KITTTITAS COUNTY COMMUNITY DEVELOPMENT SERVICES

**PREAPPLICATION CONFERENCE**  
**MEETING SUMMARY**

Date of Pre-Application Meeting: December 18, 2013 Time: 10am  
Pre-application meetings are scheduled every Wednesday after PR Team meetings.

Project name: Butler Rezone

BUTLER STORAGE
 SITE PLAN
 SR970 CLE ELUM, WASHINGTON

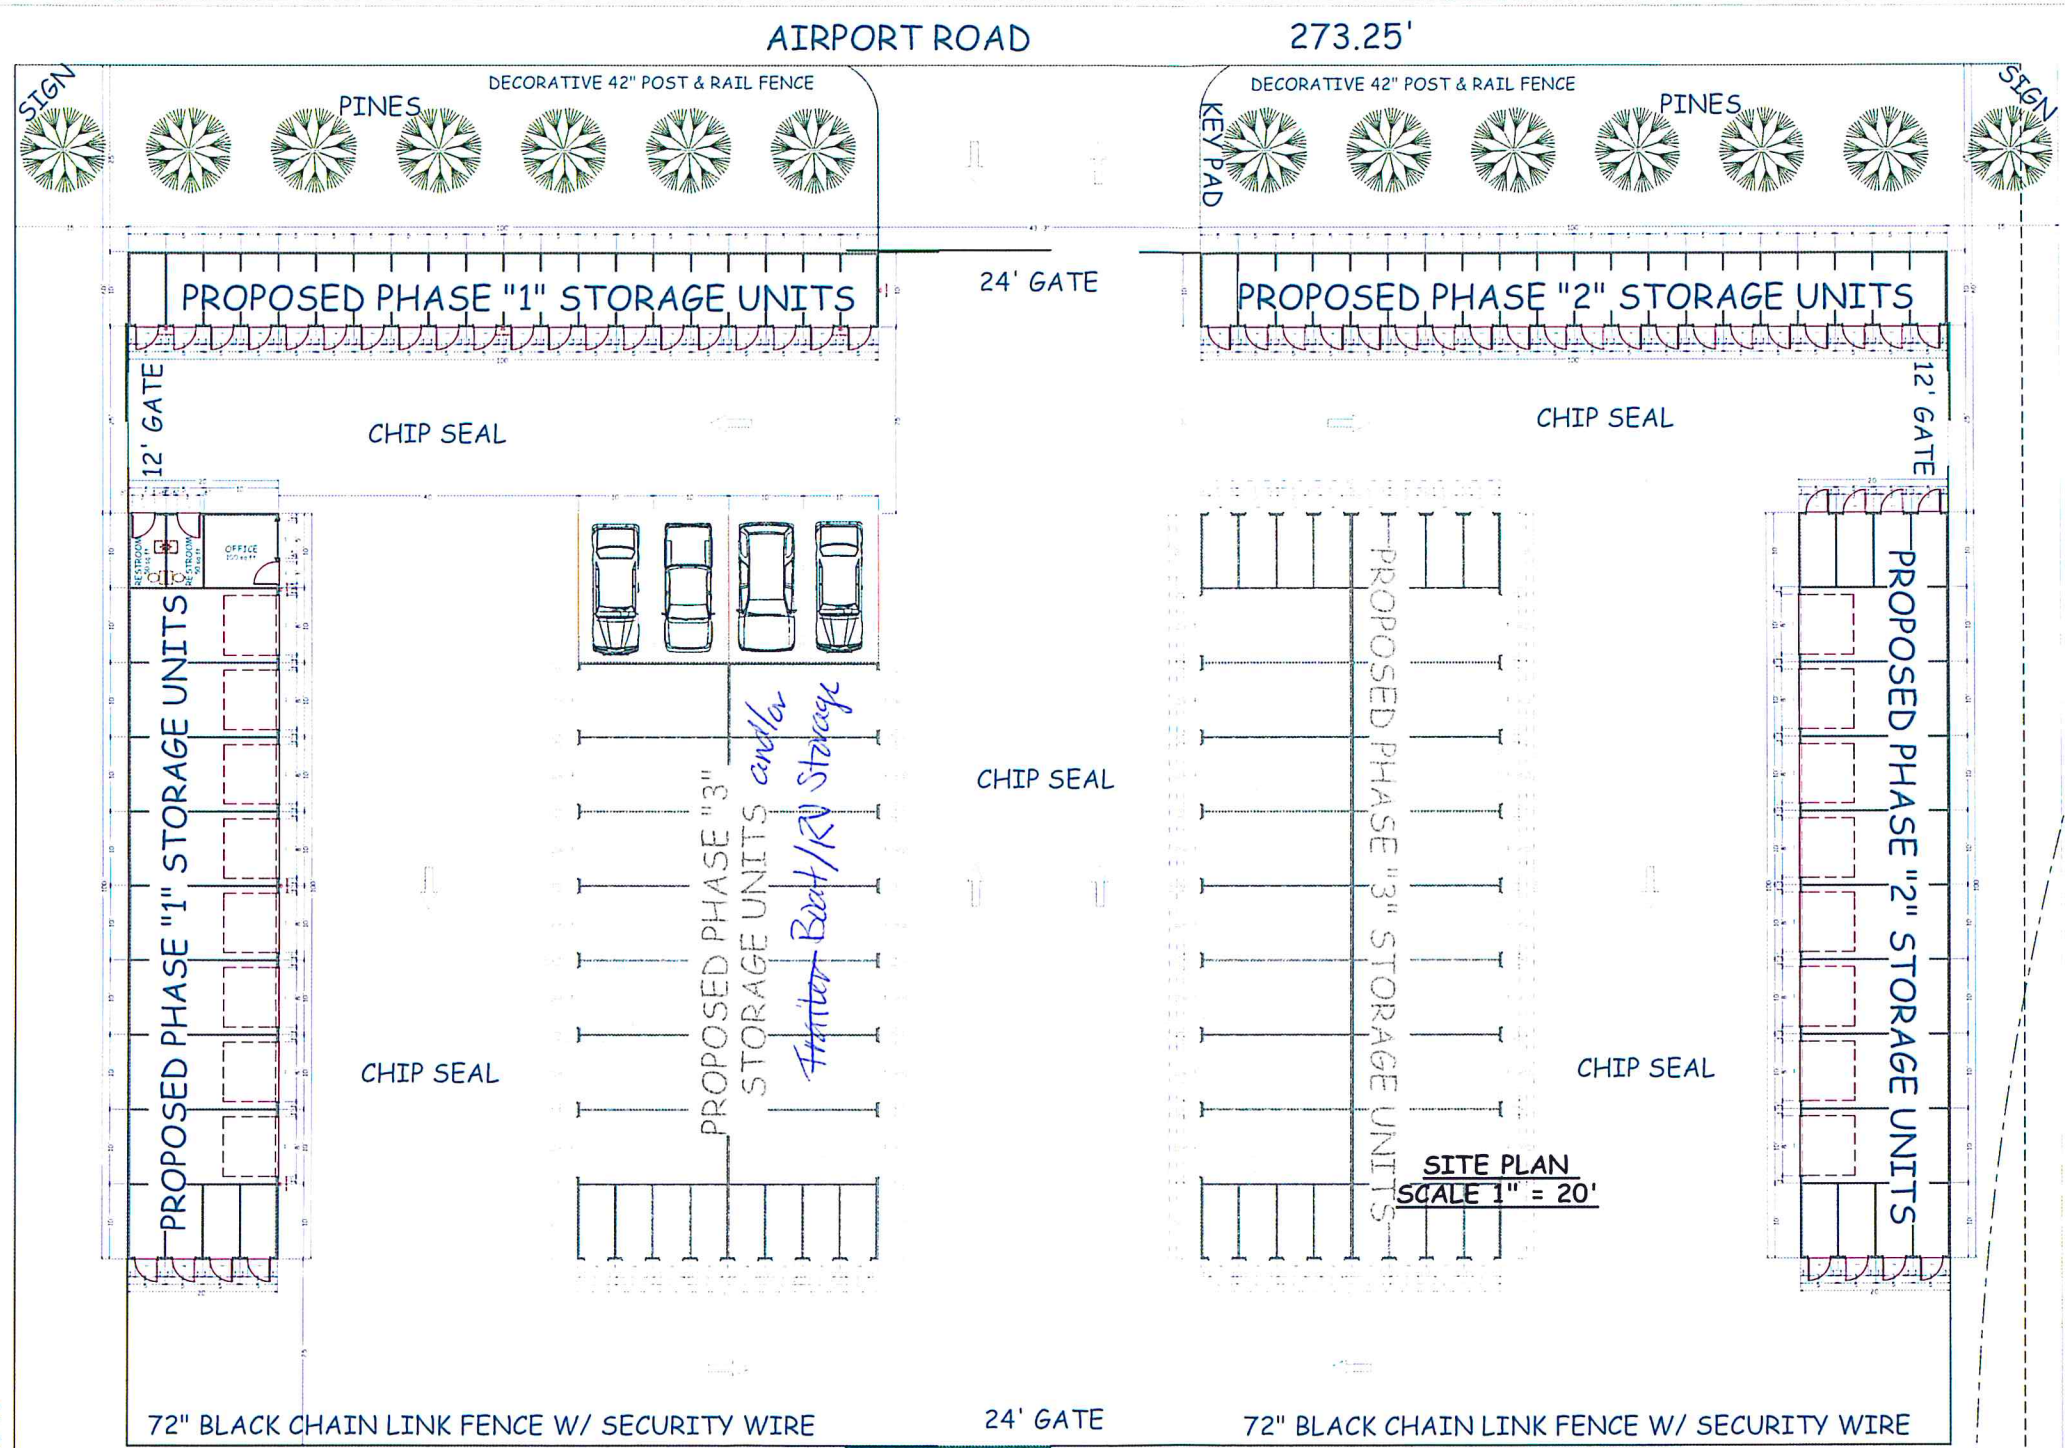
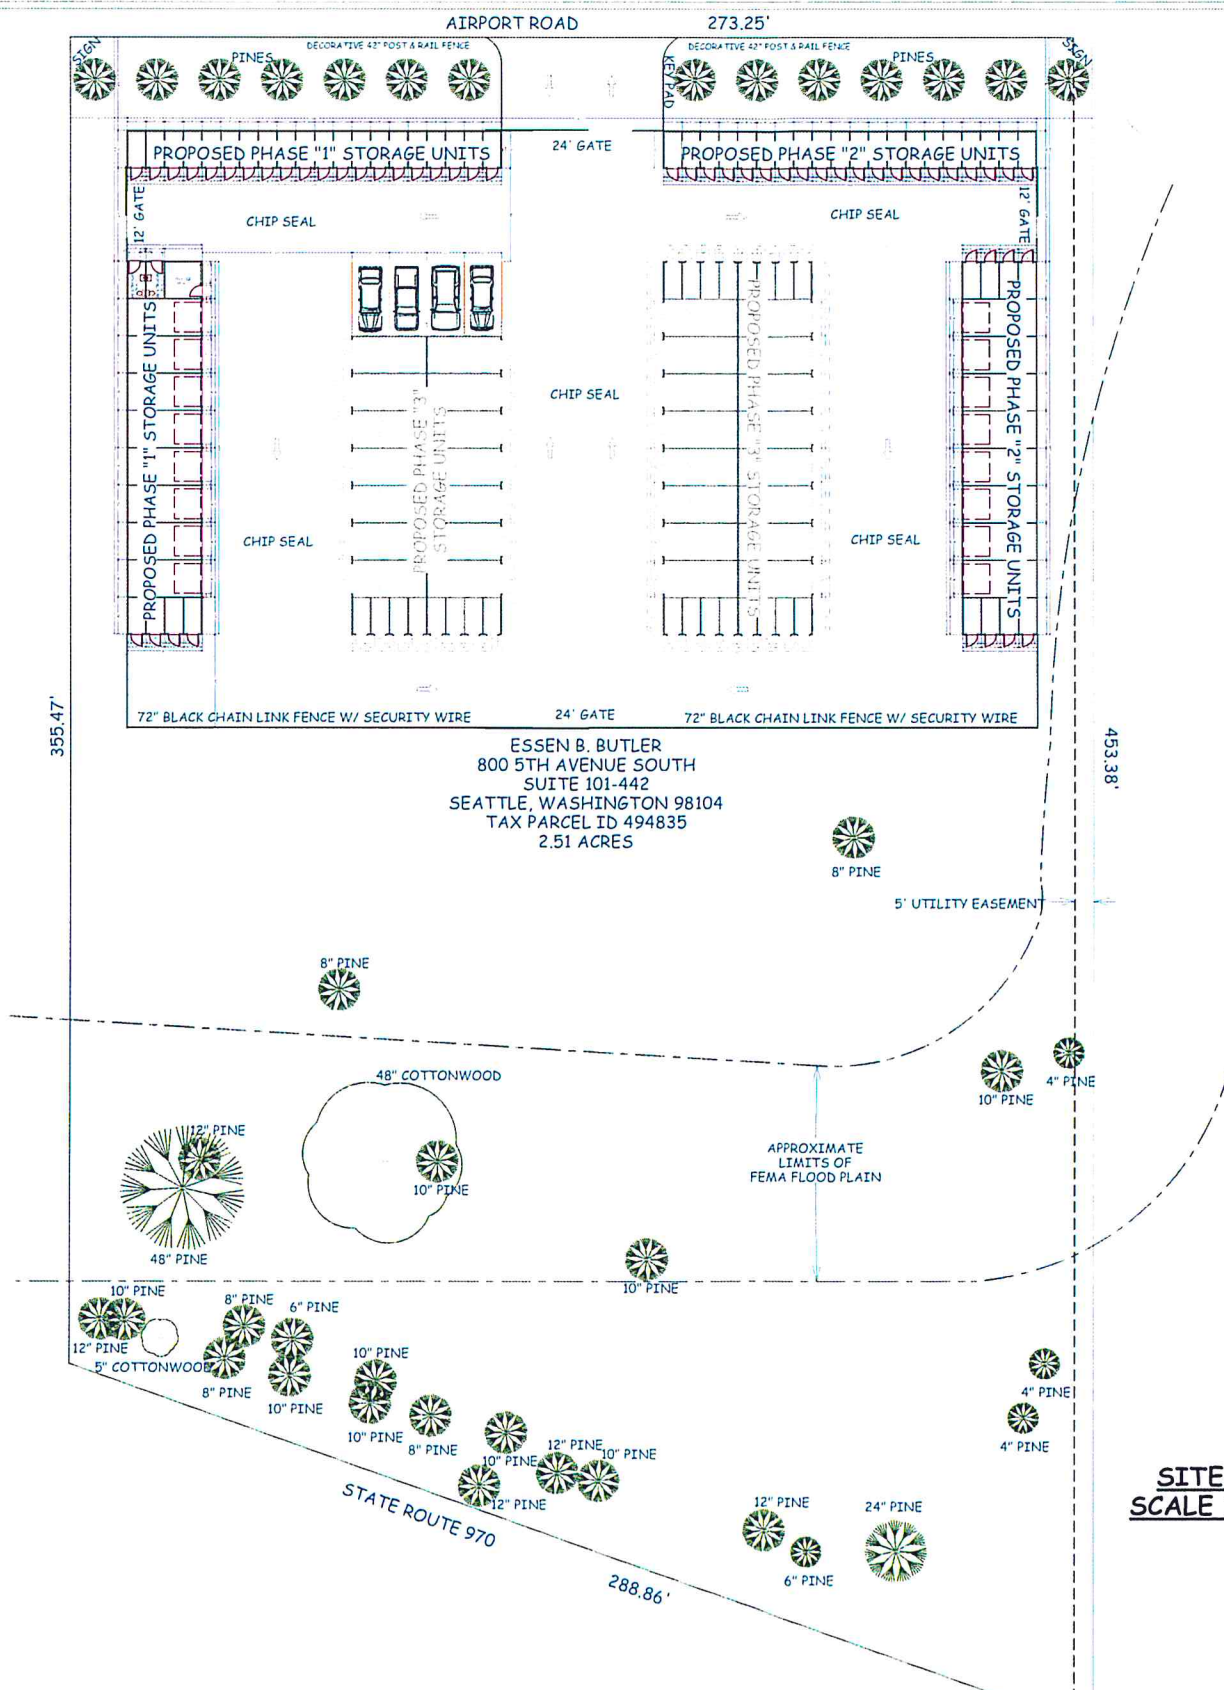
Access permit req'd. Commercial approach req'd. TIA requirement to be determined with transportation concurrency process. Must ensure gate is far enough from road shoulder.

If a well is used then it must be <sup>approved as</sup> public well as bathrooms will be accessible to the public. Consider using porta potties. If City of Cle Elum water is used the City must sign off and OK the connection to the water system. If a cistern is utilized, the

Project specific rezone w/ project narrative. Need to complete the rezone process. Hwy commercial rezone to Light Industrial for mini-storage as permitted use. Located within Cle Elum UGA. Docs contain 100 yr. floodplain. If boat/RV storage is wanted, add that to site plan. Sign - permit will be required for signage.

Fire extinguishers required every 75' (I can walk you thru this). Signage required OR additional 15' added to 25' wide roads (gate opening to be no less than 20' in width; Knox key or switch is required for emergency services. Gate opening needs to 20' min. <sup>B</sup> Knox gate switch/box for gates required

1. FULL WASHINGTON STATE ENGINEERING FOR ALL STRUCTURES.
2. AN ACCESSIBLE (HANDICAPPED) SANI-CAN WOULD BE ALLOWED SINCE THERE IS CURRENTLY NO WATER/SEWER
3. IF WATER/SEWER IS AVAILABLE - RESTROOMS REQUIRE ADA.
